MEMORANDUM

SUBJECT: SP-20-005 – Eagle Rising
Second Submittal (2022 first review)

LRA – RESPONSE TO COMMENTS
Jan 13, 2023

Engineering Division

PROPOSED
 DRAINAGE MAP
 HECRAS SECTIONS

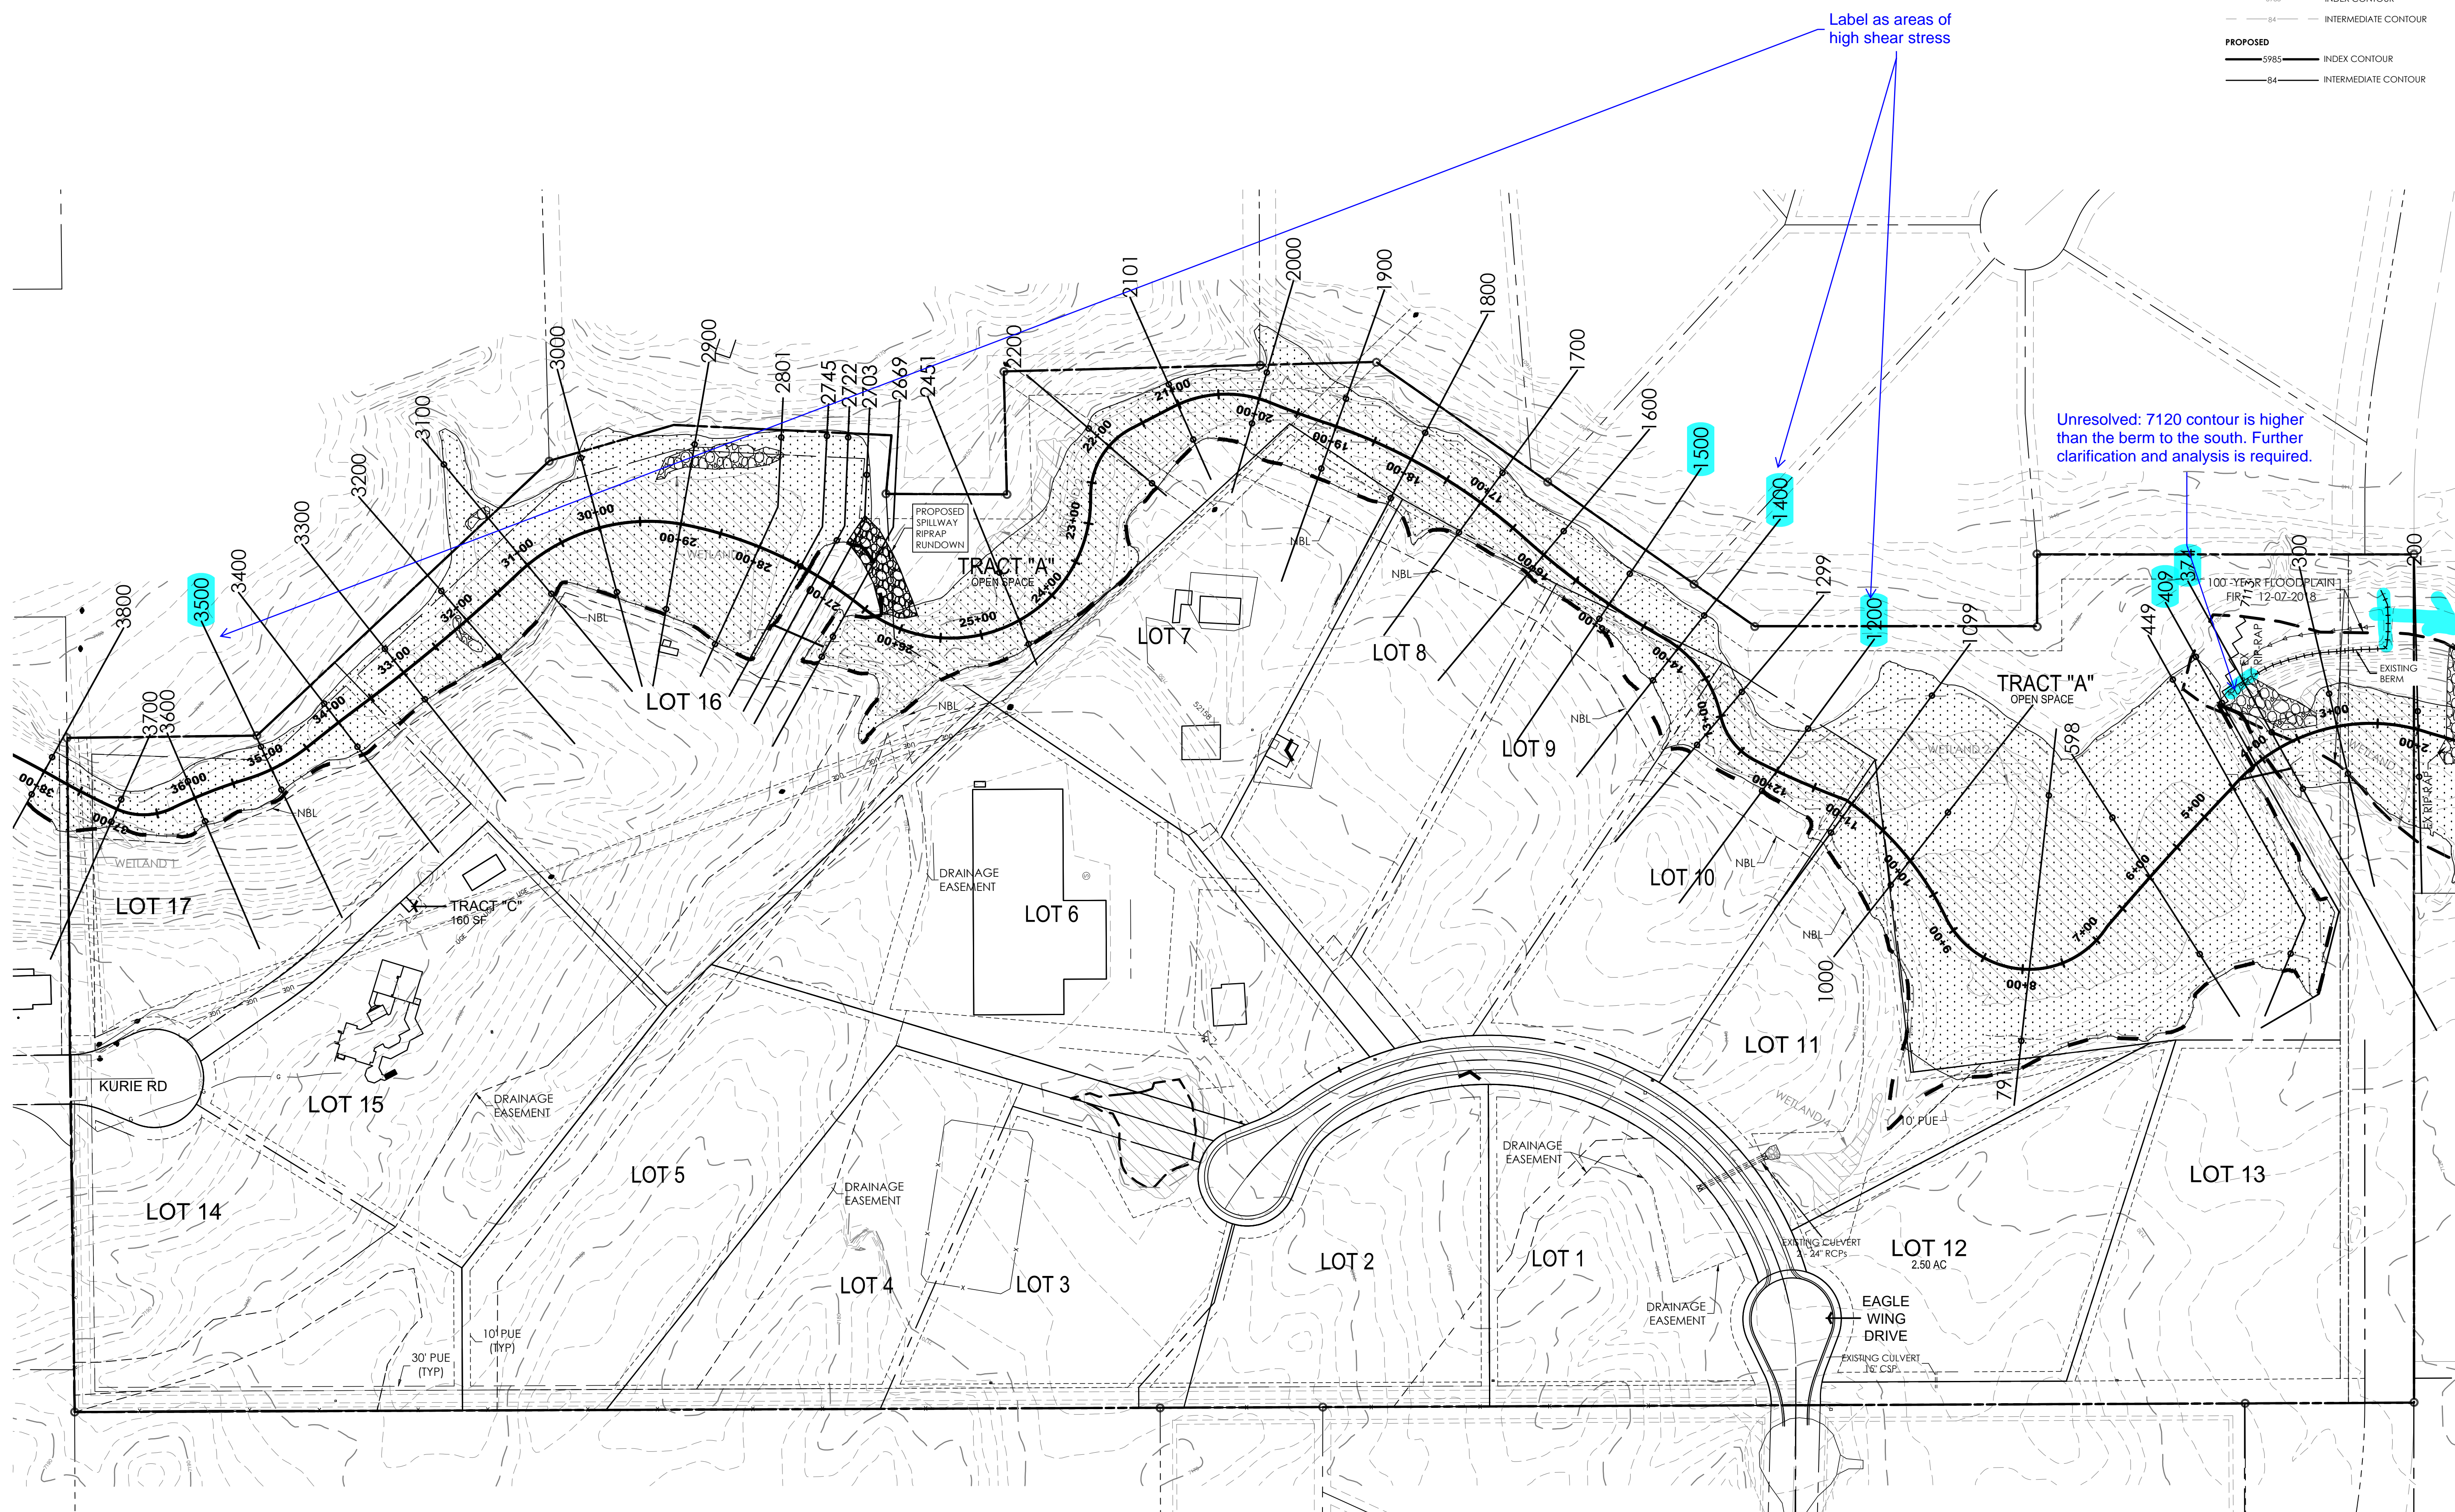
8. Show all improvements including ditch erosion protection, culvert inlet and outlet protection details on the developed drainage plan and GEC Plan.
 9. The report states that a maximum permissible velocity of 5 fps was assumed (as per Table 10-4 of DCM 1). The 5 fps figures in that table are for reed canarygrass, tall fescue, and Kentucky bluegrass. These types of lining are essentially lawns. As stated in the footnote below the table, "Grass lined channels are dependent upon assurance of continuous growth and maintenance of grass." Without assured irrigation, these grass types may not be used for design; the designer must use 2.5 fps figure for design. Alternately, the designer may use Table 10-3, but as was stated earlier in the report, the soil types onsite are a sandy loam or loamy sand. The maximum mean velocity for sandy loam is also 2.5 fps, so the design value is 2.5 fps either way. The Soils and Geology Report states that flows of 3-4 fps may be allowable but vegetative linings may increase permissible velocities to 4-7 fps. Several lot line locations with flow velocities exceeding 5 fps are identified and it is stated that no improvements are proposed; these areas need to be addressed both in terms of long-term stabilization and maintenance by an entity other than individual property owners. The velocities discussed here apply to the main channel and roadside ditches as well.
